Gunnedah Solar Farm EIS Submission

Orange Grove Sun Farm Pty Ltd (OGSF) hereby provides a submission to DPE in relation to the Gunnedah Solar Farm (Application No. 8658) EIS currently under public exhibition.

The submission raises OGSF's concerns relating to the Gunnedah Solar Farm Environmental Impact Statement (EIS) Appendix J Flood Report and Appendix I Traffic Impact Assessment.

Orange Grove Road, Gunnedah
5% AEP Flood Depth
Existing Scenario

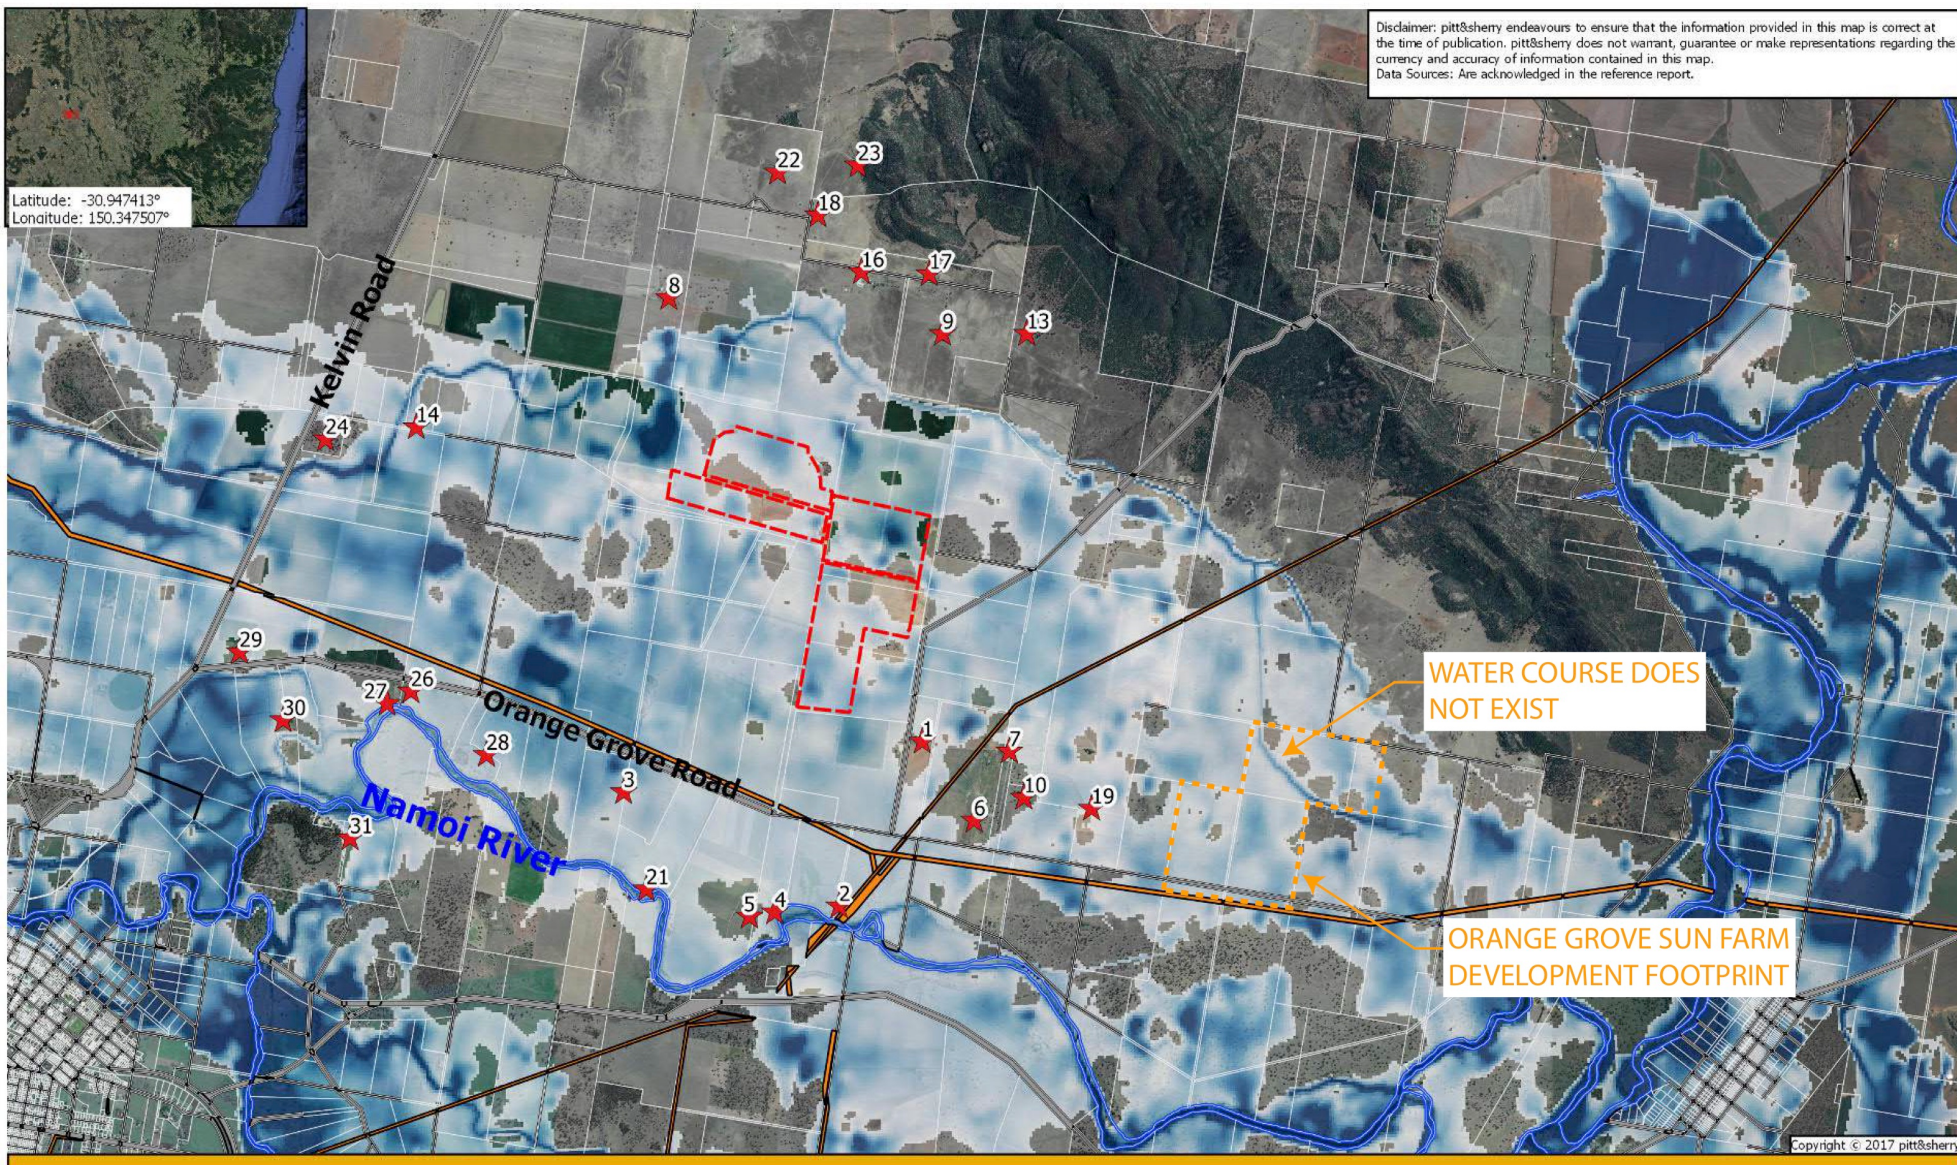
As a result of Pitt & Sherry's use of coarse data in the flood modelling for the Gunnedah Solar Farm, when the OGSF contour survey is compared to the Pitt & Sherry 1% AEP and 5% AEP *Flood Depth Existing Scenario* maps (*Attachment 2*) a misrepresentation of topographic elevations across the OGSF are present. For instance, there is a water course with flood depths in the order of 1.5 m depicted across the western side of the northern portion of the OGSF development footprint. The OGSF surveyed contours clearly show there is no channel present within that specific area, which actually has a relatively flat east to west gradient.

It is recommended that Gunnedah Solar Farm undertake a reassessment of the modelling and flood assessment utilising topographical and spatial data of appropriate resolution, and that references the use of various hydrological and flood data in the modelling and assessment process.
